Thanet Offshore Wind Farm Extension Development Consent Application
Comments on Deadline 1 Representations of the Applicant and Interested Parties

On behalf of Port of Tilbury London Limited and London Gateway Port Limited

Deadline 2 (5th February 2019)

Figure 43: Freight movements in Major Ports between 2000 and 2016.

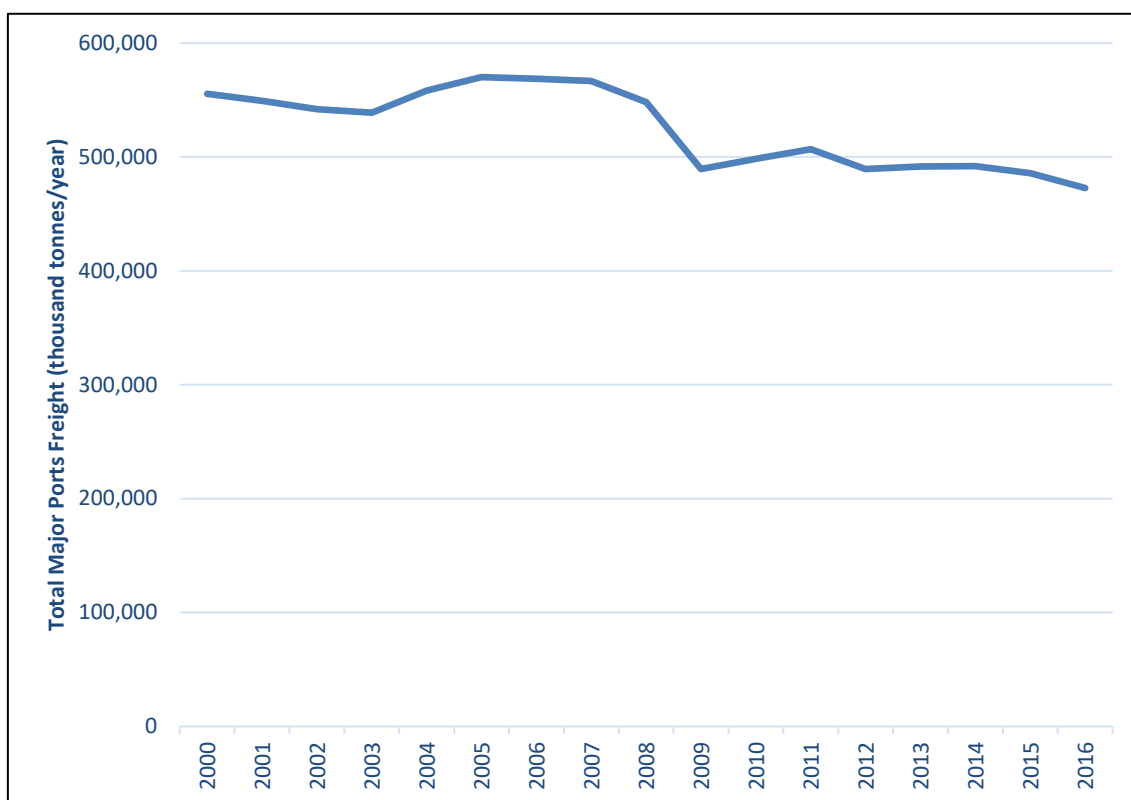
With regard to the above statements POTLL and LGPL highlight that, whilst the growth assumptions which informed the NRA may appropriately represent the growth in port throughput for the UK as a whole, they are not necessarily reflective of the ports located in the Thames Estuary. This is due to the extent of planned and committed additional port infrastructure, the competitive nature of the UK ports industry and the trend towards use of ports in the South East. This is highlighted by Table

Notably the above indicates growth of 22.5% combined between DPWLG and POTL from 2016 (the end of the study period which informed the growth assumptions utilised in the NRA) to 2018.

Thus, whilst a trend to increased average ship size (and thus capacity) may be expected, it is likely to occur alongside a significant increase in the number of vessel visits to Thames-based port facilities. POTLL and LGPL suggest therefore that the growth assumptions which inform the NRA are flawed.

Figure 44: Freight movements in Thames Estuary between 2000 and 2016.

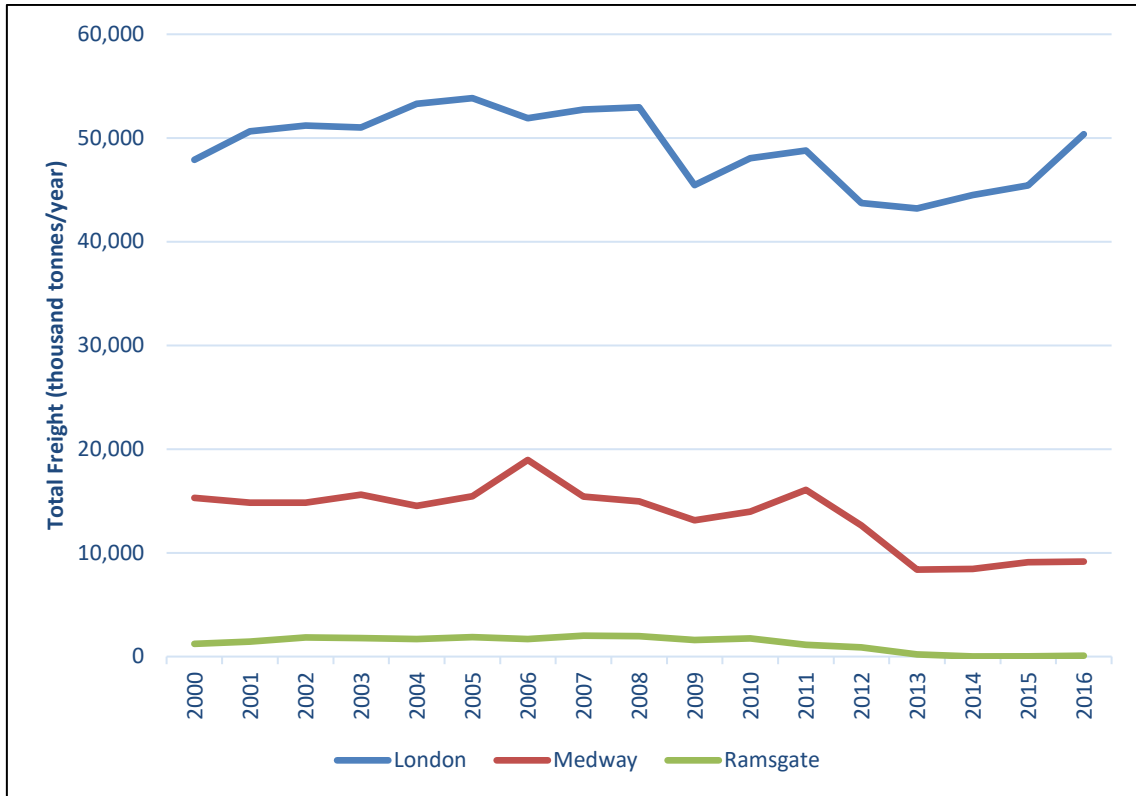
1.1 below, which indicates the growth in total throughput at DP World London Gateway (DPWLG) and Port of Tilbury London (POTL) over the 3 year period from 2015 to 2018:
